**From:** Contact Centre (CRM) <contact@ribblevalley.gov.uk>  
**Sent:** 04 August 2022 13:07  
**To:** Planning  
**Subject:** Planning Application Comments - 3/2022/0632 FS-Case-442081631

**Planning Application Reference No.:** 3/2022/0632

**Address of Development:** Pendle Mill  
Pendle Rd  
Clitheroe

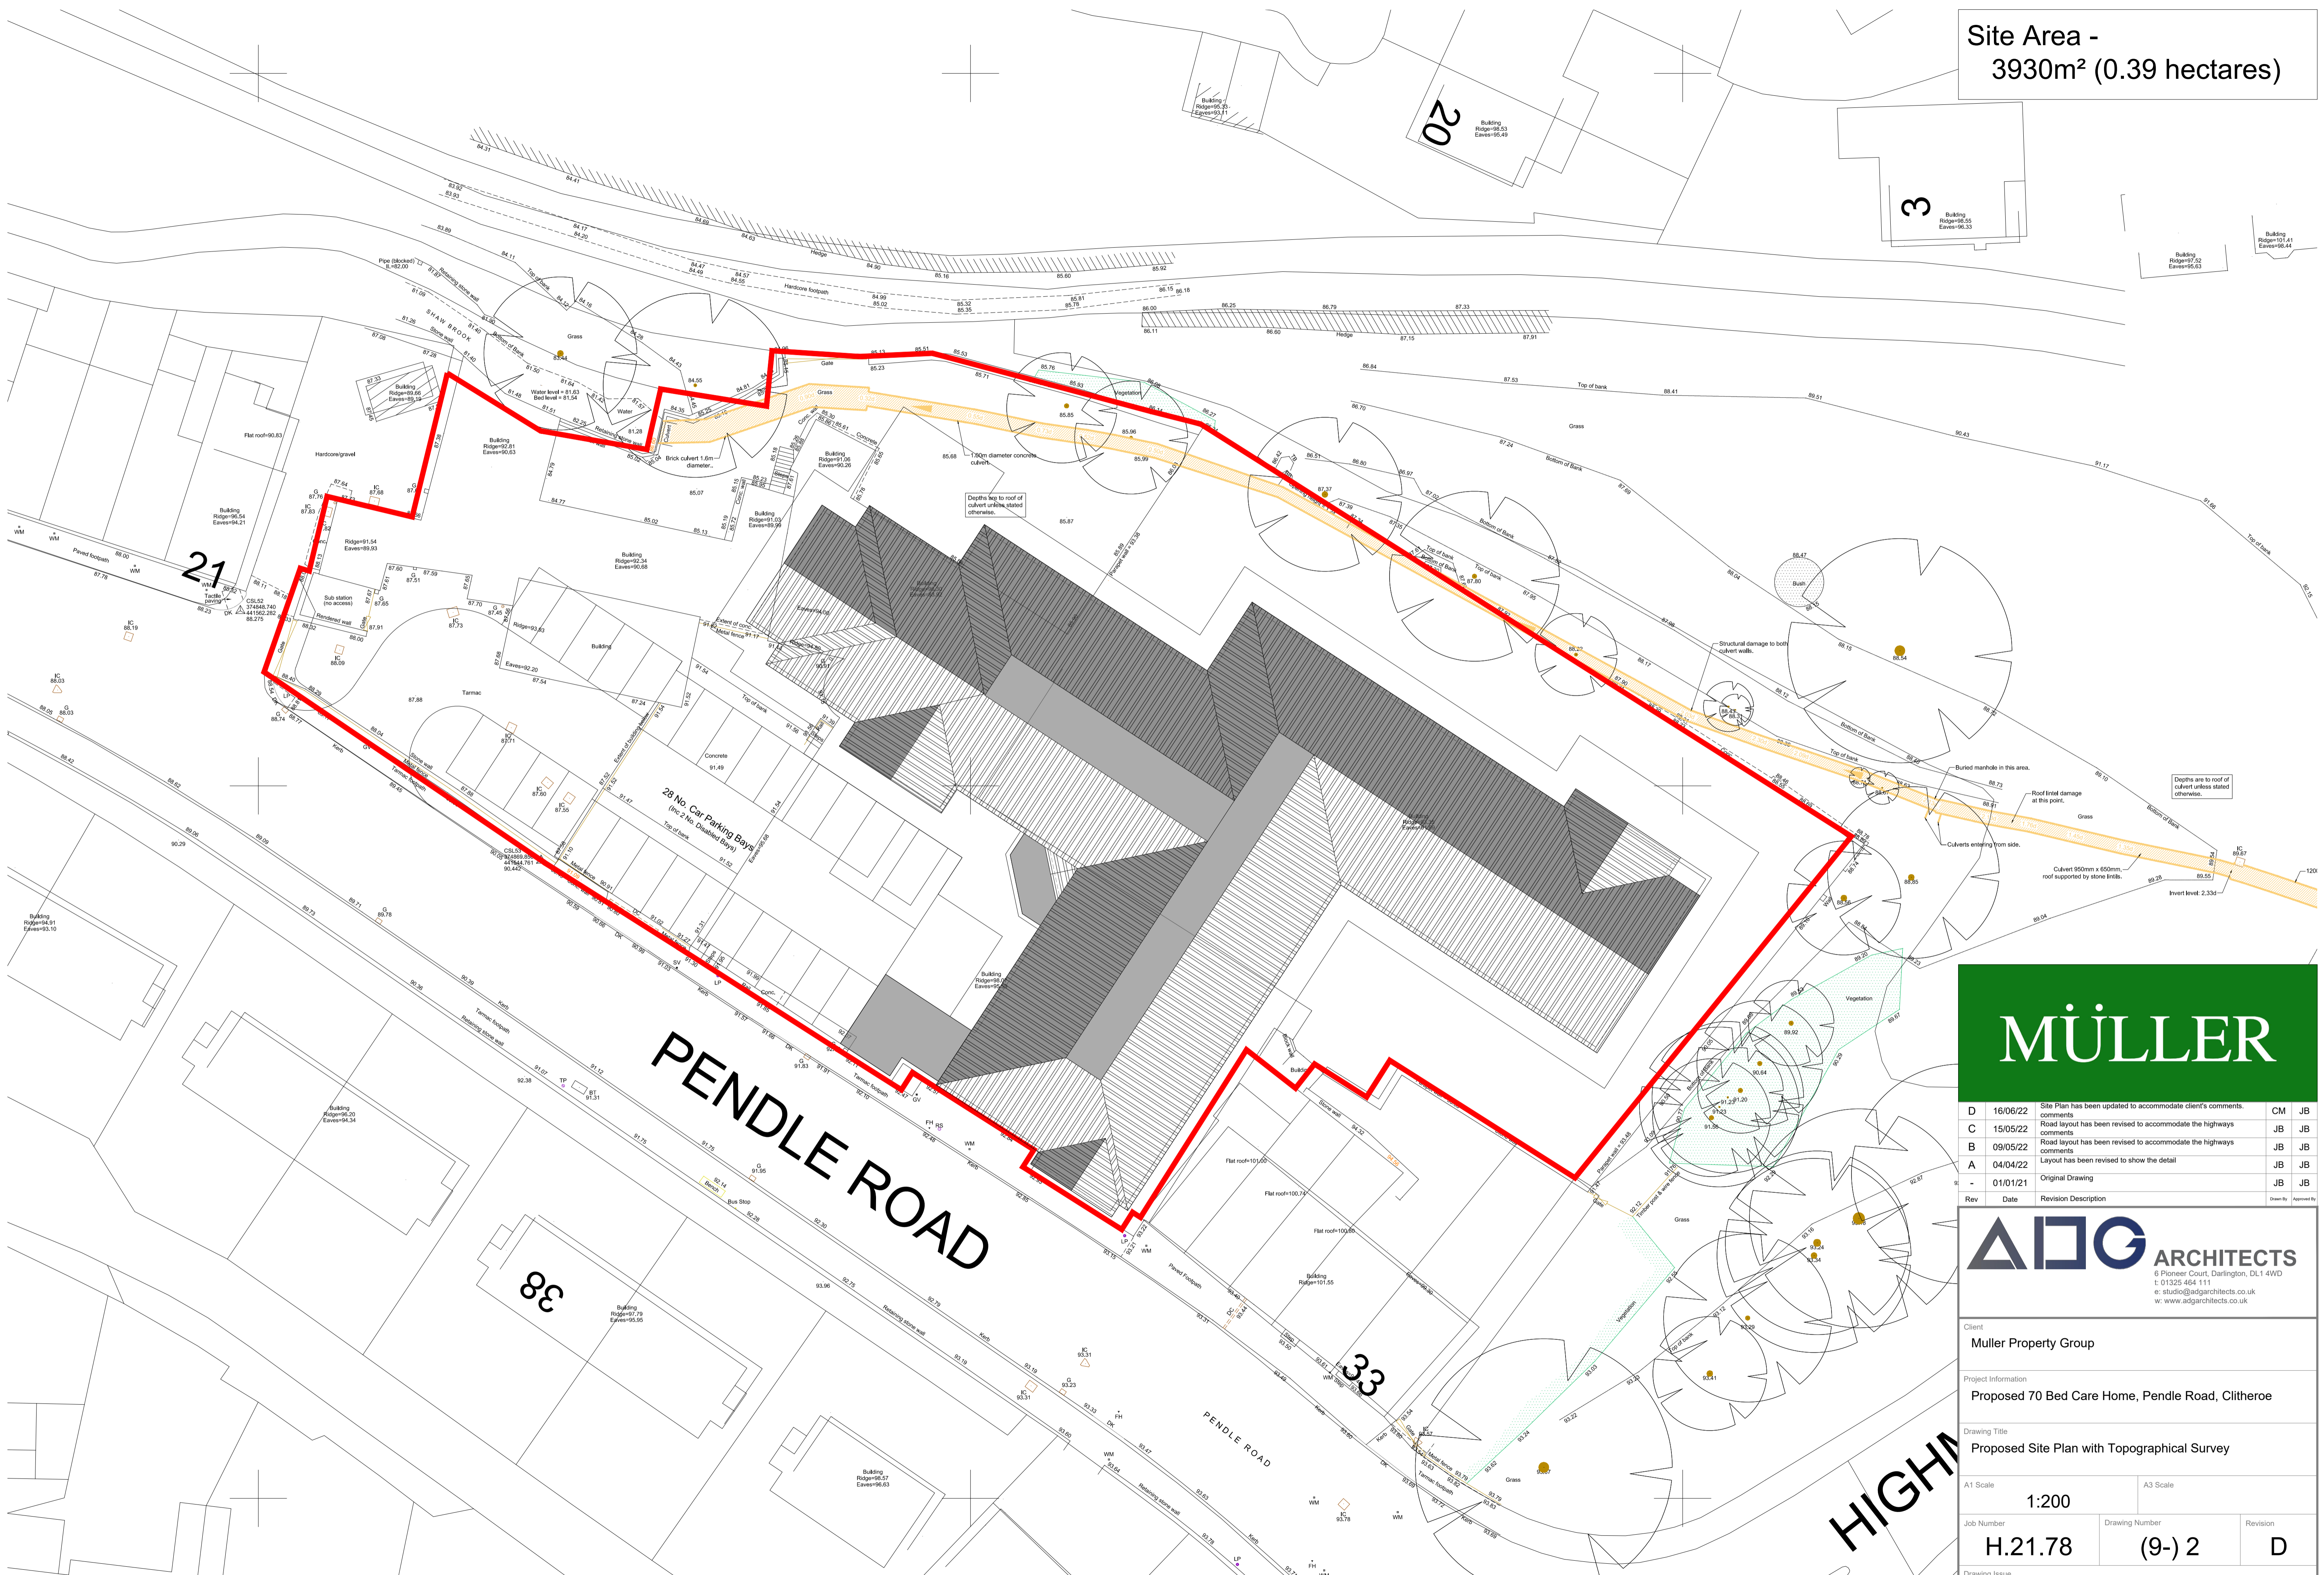
**Comments:** The project should not be dismissed out of hand but is too large for the site. There is very limited parking for a 70 bed home to accommodate daily visitors and staff. In addition there is only one access point for food deliveries, Ambulance traffic etc which is set at an acute angle to Pendle Road. Currently when hgvs arrive to deliver to the mill they have to block Pendle Road itself to turn and or reverse into the yard.

Assume a daily staff regime of between 40 and 60, visitors of say 30-50 changing throughout the day, where will these 100 vehicles park?
